From: Ian Stocks [REDACTED] **On Behalf Of** FRS Water and Access
Sent: 20 April 2022 16:09
To: Planning.Responses <Planning.Responses@arun.gov.uk>
Subject: Planning consultation - BR/50/22/PD Land to the rear of 27 Station Road Bognor Regis PO21 1QD

Having viewed the plans for planning application BR/50/22/PD, for Prior Approval under Schedule 2 Part 3 Class MA for the Change of Use from Commercial, Business and Services (Use Class E) to Dwellinghouse (Use Class C3), evidence is required to show there is suitable access requirements for a fire appliance to gain access to within 45 metres of all areas inside the dwelling.

BLOCK PLAN
Sc. 1:500

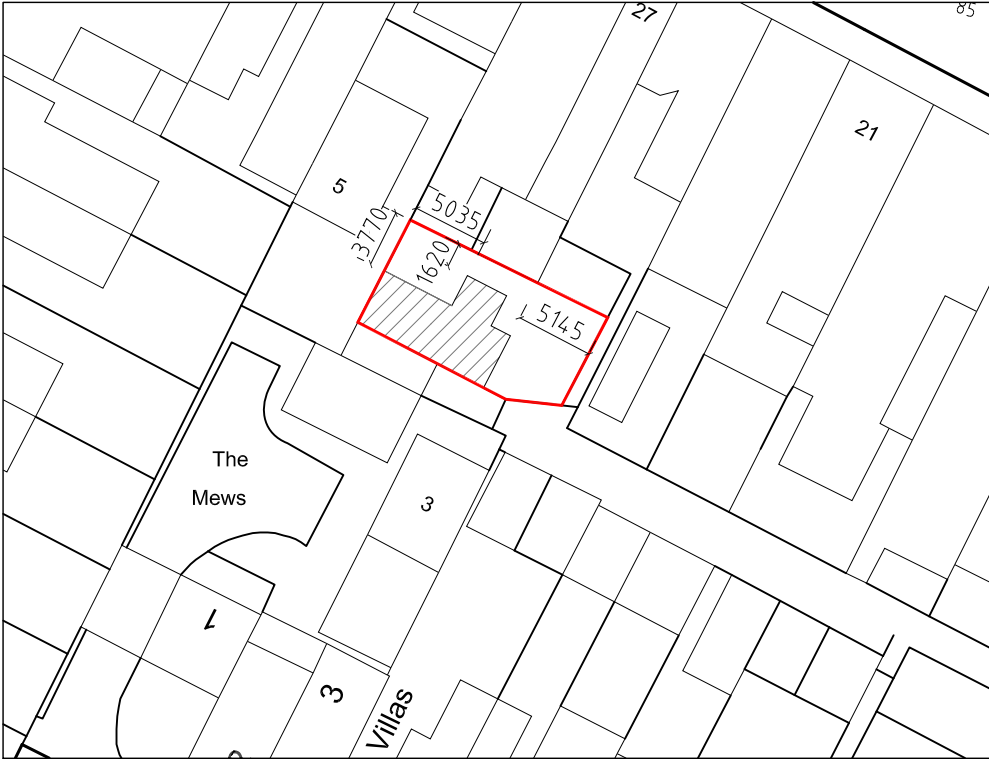
In accordance with the requirements of Approved Document – B (AD-B) Volume 1 2019 edition: B5 section 13, vehicle access for a pump appliance should be provided to within 45 metres of every point within each dwelling. The intended dwelling is 60 metres from the main road so fire appliance access to this site is key. Any areas not within 45 metres of a fire appliance will need to be mitigated by the installation of domestic sprinkler or water mist system complying with BS 9251 or BS 8458 standard.

Evidence is also required to show sufficient turning facility is provided for a fire appliance to turn and make their exit, a fire appliance should not need to reverse more than 20 metres, as identified in AD-B Vol 1 - B5 section 13.
